RFI

RFI #: 116
Date: 5/14/2012
Job: EB-02 Keller Springs Lofts
Phone: 877-777-5115

Subject: Mechanical Plans Do Not Match Architectural Plans

2.6HC

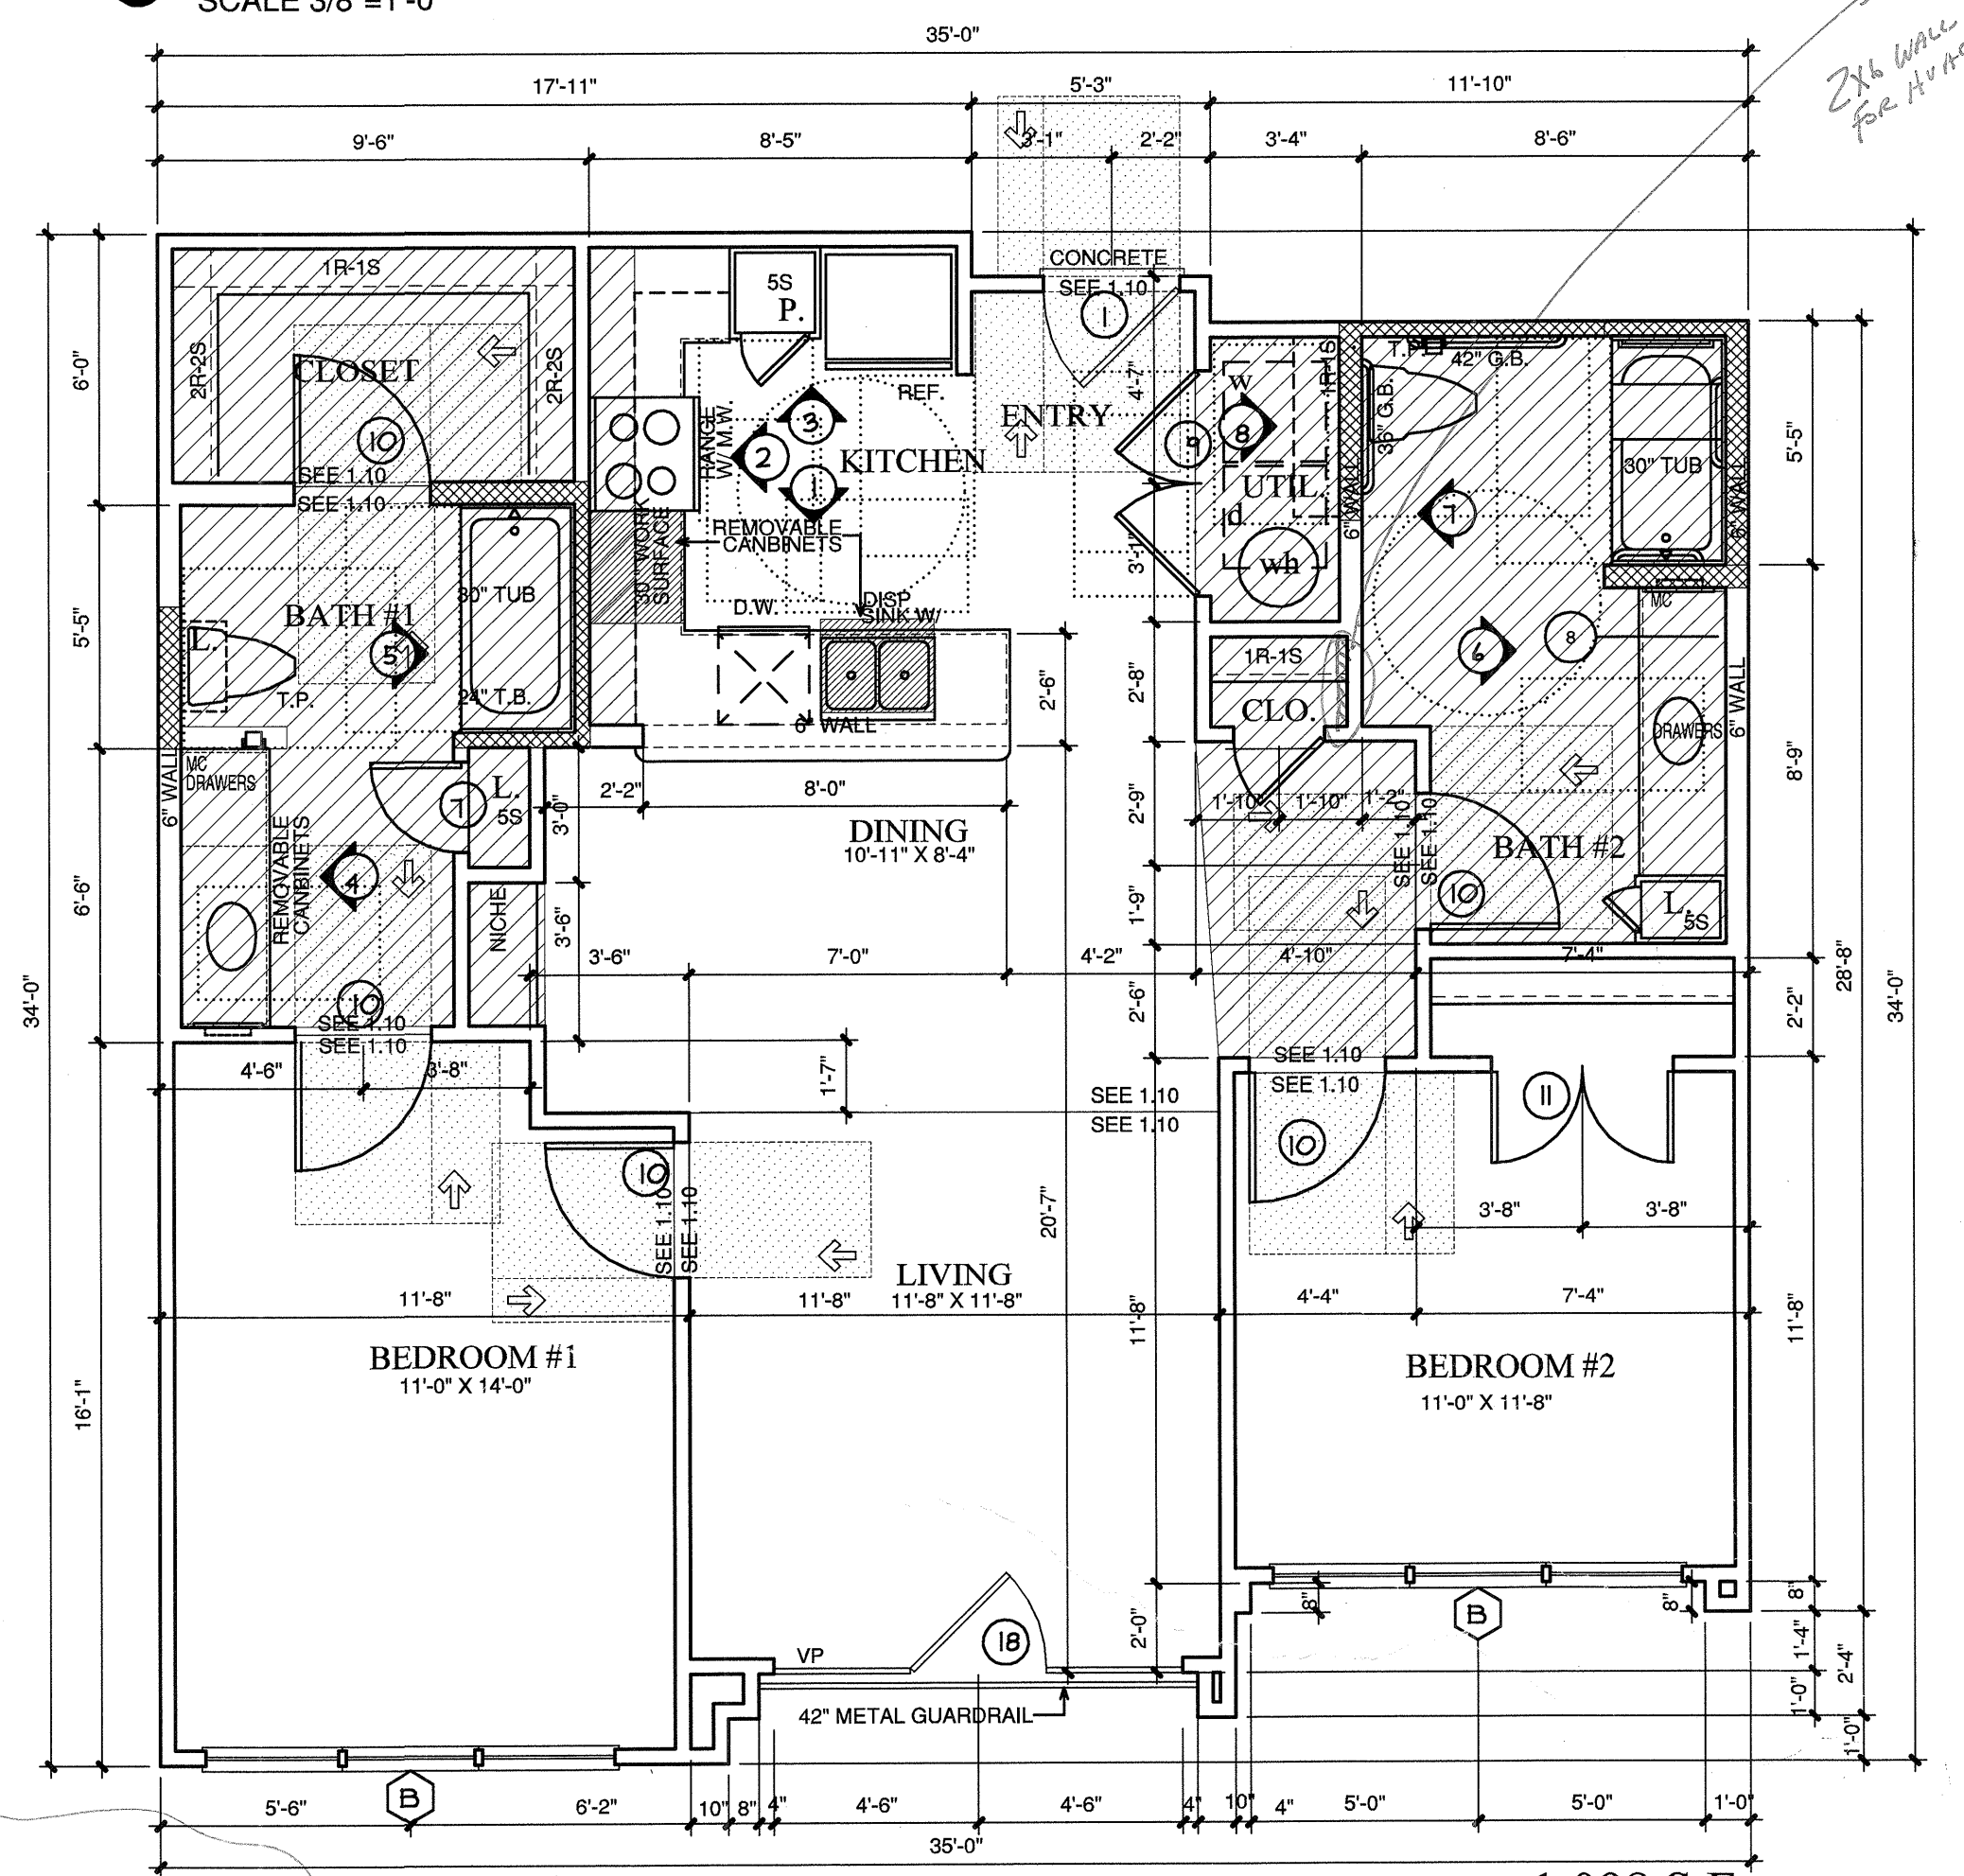
Date Required: 5/22/2012
Request:
The B1-HC unit on sheet M2.11 has not been revised and doesn't match the floorplan of the B1-HC unit on A2.6HC. Please revise and reply.
Requested by: David Miller
Embrey Builders LLC

Response:
See attached for updated plan
Answered by: Heath Parnell
Jordan & Skala Engineers, Inc.
Answered date: August 23, 2012
